From: David Lowin
Sent: 19 July 2021 07:34
To: DC Support
Cc: Rebekah Morgan
Subject: FW: Planning Application 20/01830/F - Suitability of 'Compact' MOVA

From: Paul Troop <pault@gclaw.co.uk>
Sent: 16 July 2021 17:10
To: White, Joy - Communities <joy.white@oxfordshire.gov.uk>
Cc: Broughton, Ben - Communities <Ben.Broughton@Oxfordshire.gov.uk>; Richardson, Julian - Communities <Julian.Richardson@Oxfordshire.gov.uk>; Manku, Amrik - Communities <Amrik.Manku@Oxfordshire.gov.uk>; Kirby, Chloe - Communities <Chloe.Kirby@Oxfordshire.gov.uk>; Andy Bateson <Andy.Bateson@cherwell-dc.gov.uk>; Rebekah Morgan <rebekah.morgan@cherwell-dc.gov.uk>; David Lowin <David.Lowin@Cherwell-DC.gov.uk>; Councillor Daniel Sames <Daniel.Sames@Cherwell-DC.gov.uk>; nick.jones-hill@watermangroup.com; john.jowitt@pjplanning.com; darryl.pearson@watermangroup.com
Subject: Re: Planning Application 20/01830/F - Suitability of 'Compact' MOVA

Drawing 3: Proposed Site GA Plan (Drawing ref. WIE11386-145-03-001)

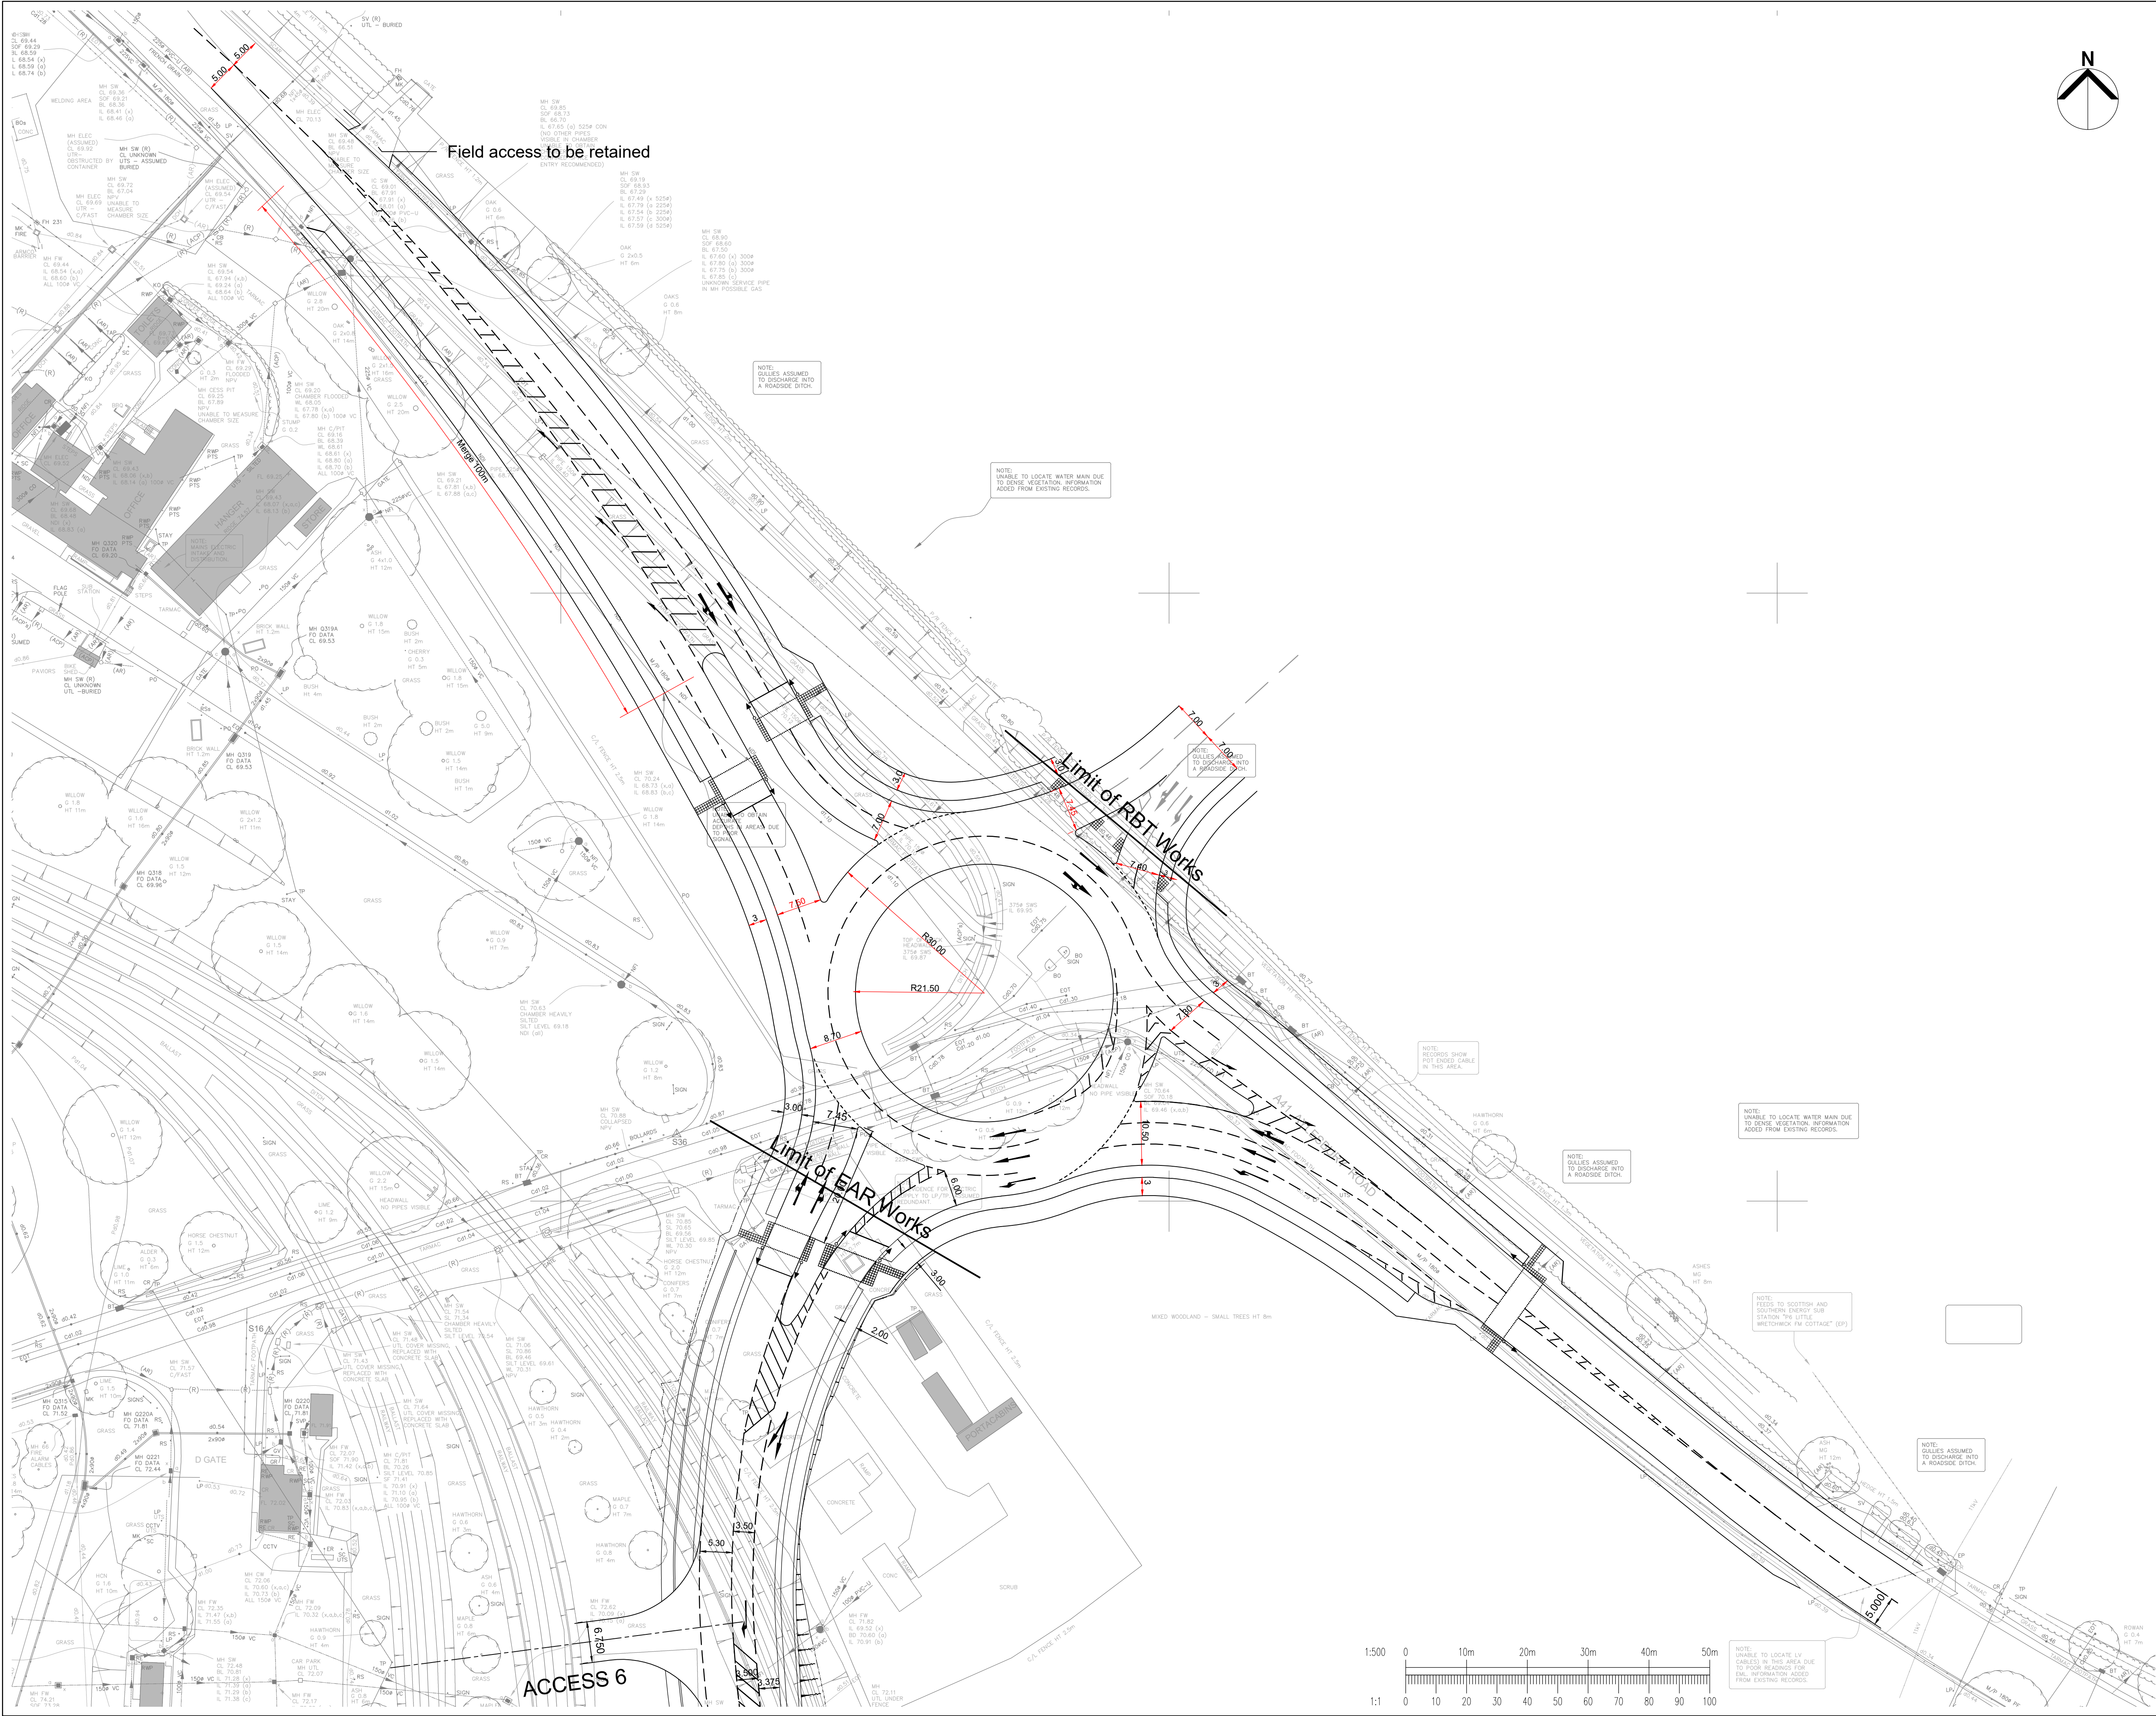
I write further to our correspondence and meeting with OCC's Traffic Signals Team regarding the recommendation to move the shared crossing adjacent to the proposed Pioneer Roundabout on the A41. We have serious concerns that OCC's rationale for this proposal is flawed.

The OCC Traffic Signals Team proposes that, purportedly for safety reasons, the shared crossing on the Bicester side be moved away from the roundabout (and away from the desire line) so that a 'compact' Microprocessor Optimised Vehicle Actuation ('MOVA') system can be installed. We have serious doubts about the advisability of such a proposal from a safety perspective, in addition to the negative impact on active travel.

Furthermore, as you will be aware, a compact MOVA is one that omits the 'IN' detector (located 85-100m from a crossing) and only uses an 'X' detector (located 40-45m from a crossing). However, the OCC Traffic Signals Team does not seem to have appreciated that a compact MOVA is only suitable for 'low-speed' junctions, ie those with a 30mph speed limit and an 85th percentile speed below 35mph (TRL MOVA Application Guide 45, Issue G, 18, 109, 264). A compact MOVA could not therefore be installed at this junction.

I would furthermore note that both the TRL guidance (270) and the Department for Transport's Traffic Signs Manual (18.4.2 and Table 18-1) both point out that in locations suitable for a compact MOVA, fixed signal timing that does not require detectors is equally suitable.

In these circumstances, we would therefore suggest that the most advisable solution from a safety and usability perspective would be to reclassify the speed limit for the roundabout as 30mph, leave the crossing in its current location, and use a fixed signal timing.

Regarding the design speed, the outcome of a proposed change of speed limit east of the roundabout to 40mph is not expected until the autumn, following consultation. It is reasonable that a speed limit reduction to 30mph at the roundabout itself could be promoted, once the two side arms are open. As the works need to start sooner than both these events, unfortunately the design has to take into account the current speed limit.
